**From:** blackforestnews@earthlink.net  
**Sent:** Tuesday, August 28, 2018 5:47 PM  
**To:** Kari Parsons  
**Cc:** me  
**Subject:** Re: For BOTH Redtail Ranch and Flying Horse North Preliminary Plans and Respective Plats

**Subject:** For BOTH Redtail Ranch and Flying Horse North Preliminary Plans and Respective Plats

*Regarding the definition of what is needed for Principal Arterial in MTCP and ECM and inconsistencies among PUD Rezone approvals for Flying Horse North (Black Forest Road) in 2016, Retreat at Timber Ridge on 3-27-2018 (Vollmer Road) and the current Draft Preliminary Plan for Redtail Ranch (March 2018).*

For: Redtail Ranch Adjacent Landowner comment - August 28, 2018  
Preliminary Plan and Final Plat  
re: Drainage - spillway for Stock Pond Design Point D2 on Lot 3, Kettle Creek Basin  
Preliminary/Final Drainage Report for Redtail Ranch Filing 1 July 2018  
for Michael Ludwig by Marc Whorton PE - Classic Engineering

RETAIL RANCH
PRELIMINARY/FINAL DRAINAGE REPORT
DEVELOPED DRAINAGE MAP

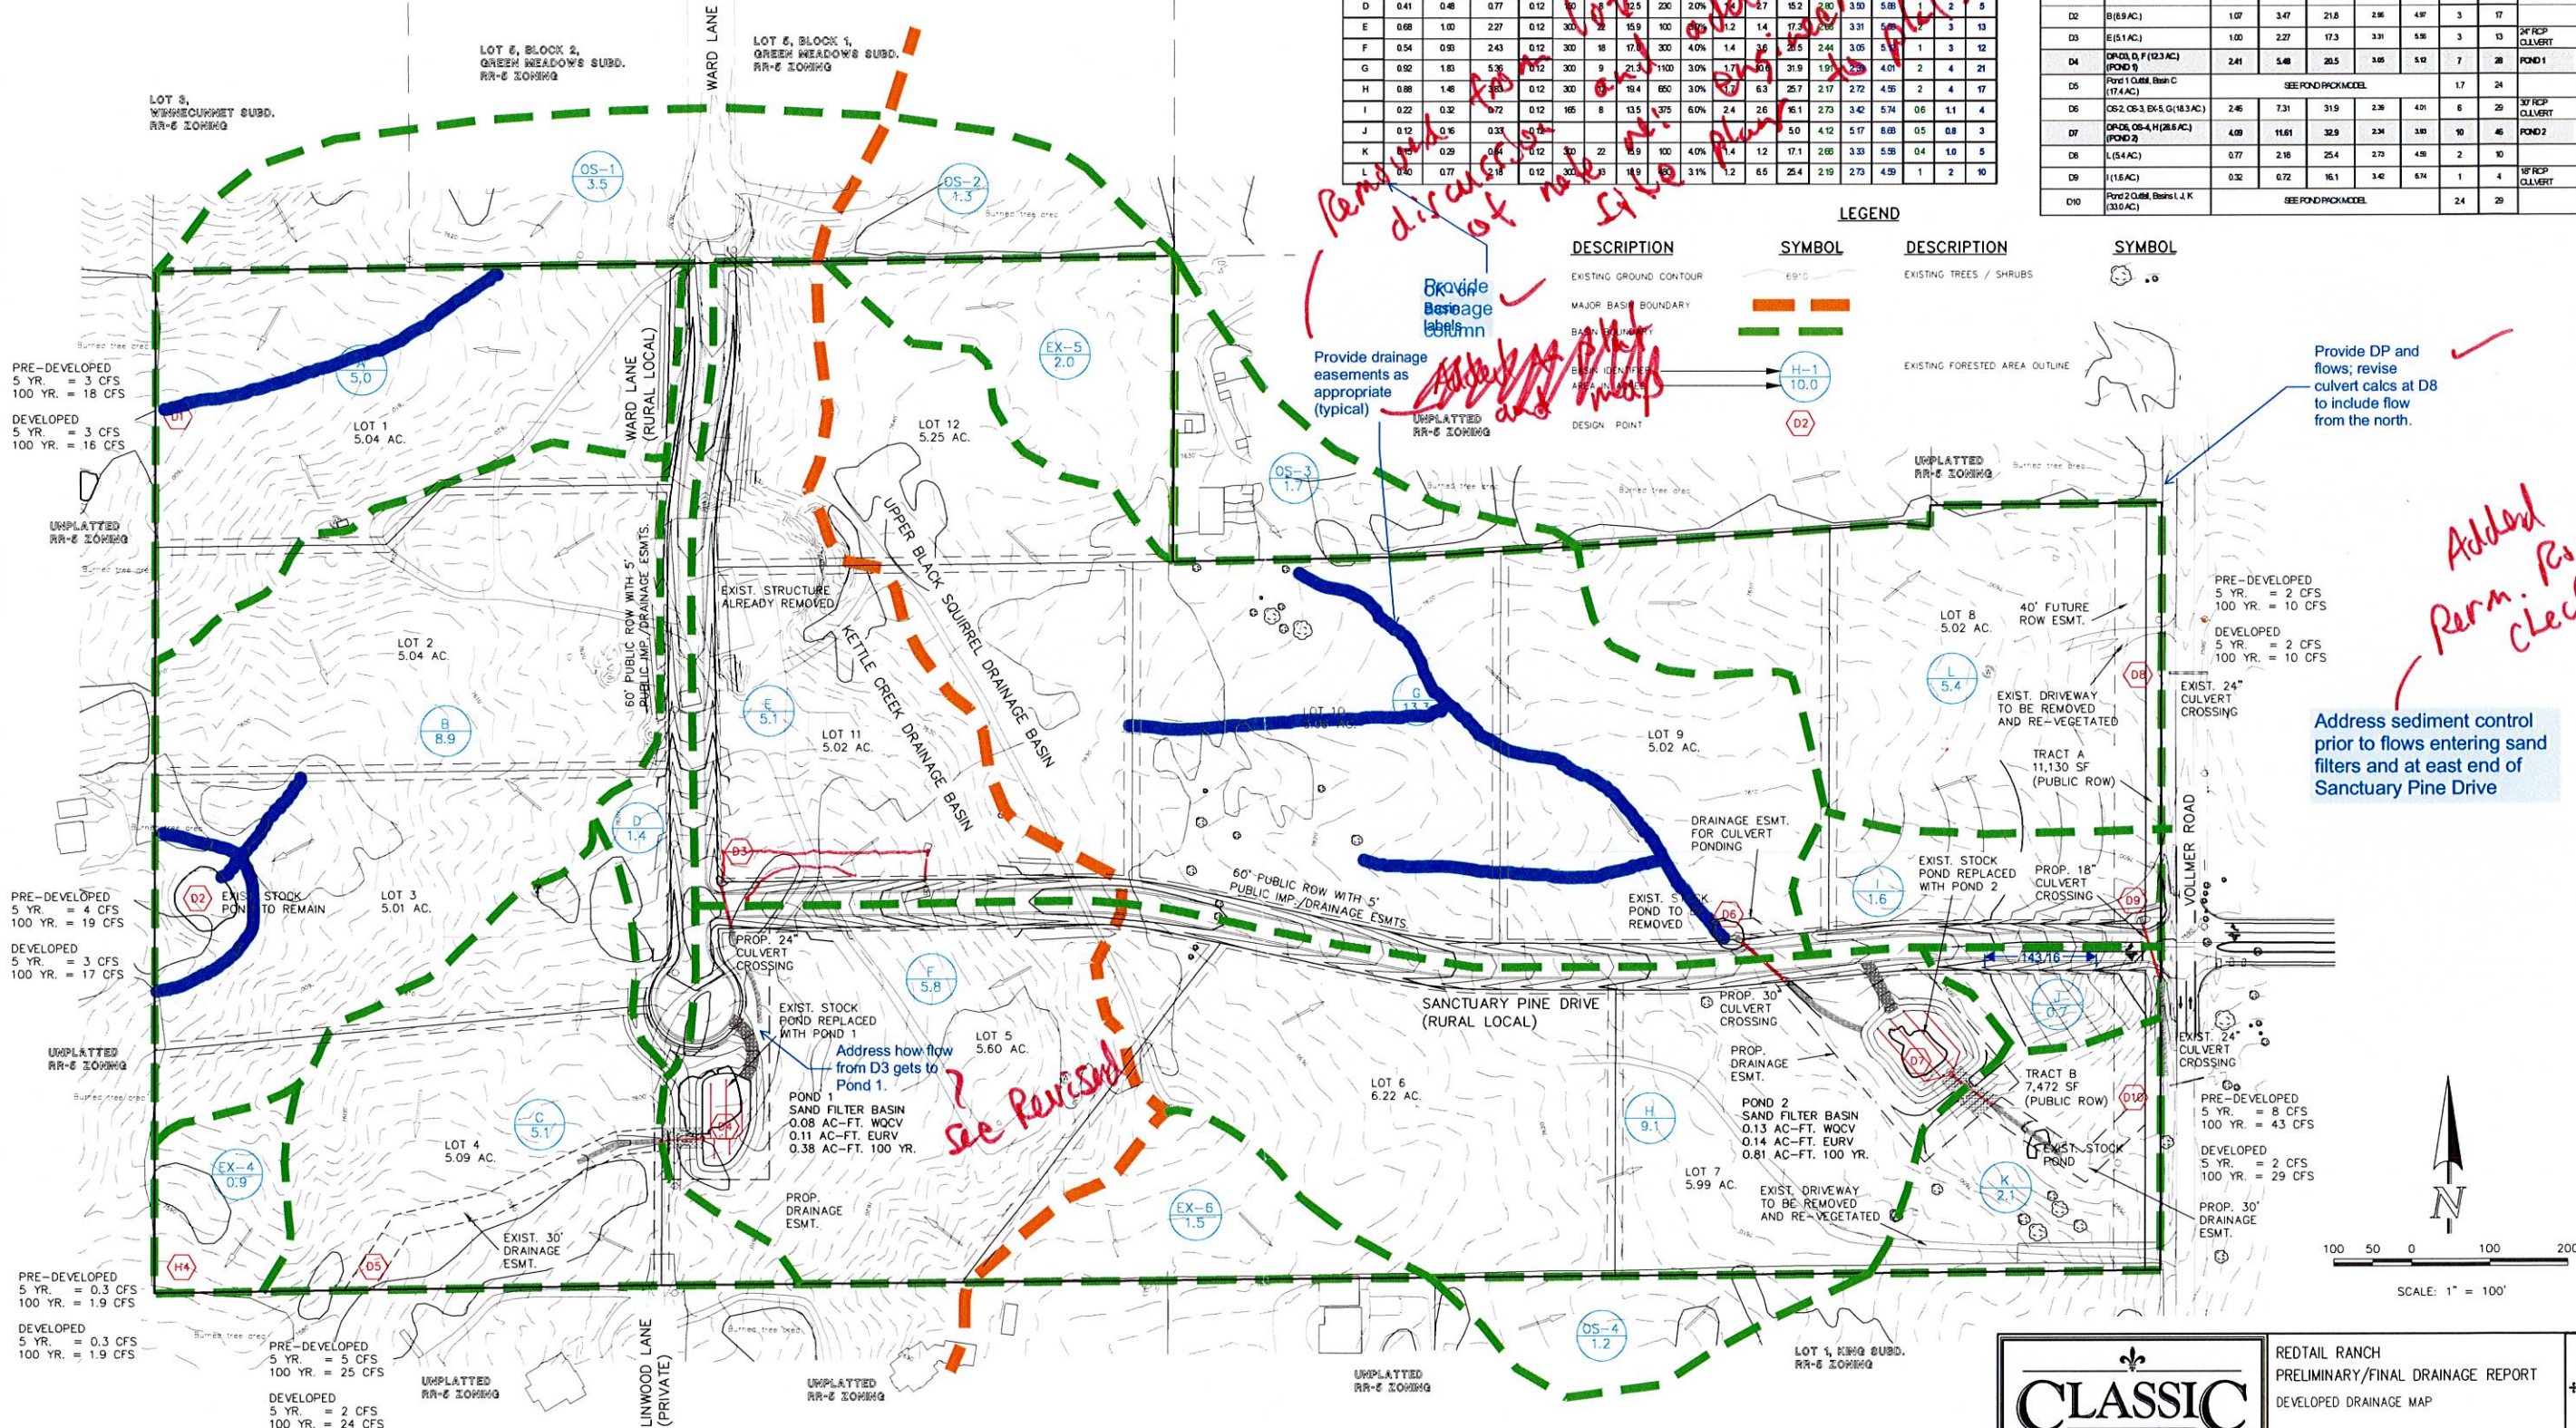
**Regarding lack of spillway and previous overtopping of dam when pond is full**

I am requesting here that Mr. Ludwig put in a proper spillway on the south side of the pond, with a riprap base for flash-flood events. There is grass present, but the gradient is short and steep to the property line and I believe it should have some rocks to attenuate the flow and protect the surface on the Redtail Ranch property. this drainage problem and liability should not be passed on to a new landowner for Lot 3.

Perhaps Mr. Whorton could bring out a transit and determine how much the south edge of the pond needs to be lowered to put in a proper spillway to conduct excess flow onto my land and keep the water below the bordering trees.

I am asking that a proper spillway be constructed to the left (east) of the trees with a riprap channel to maintain the pond surface below the tree level and far enough below the dam to safely accommodate water from heavy precipitation events like the one in August of 2008.
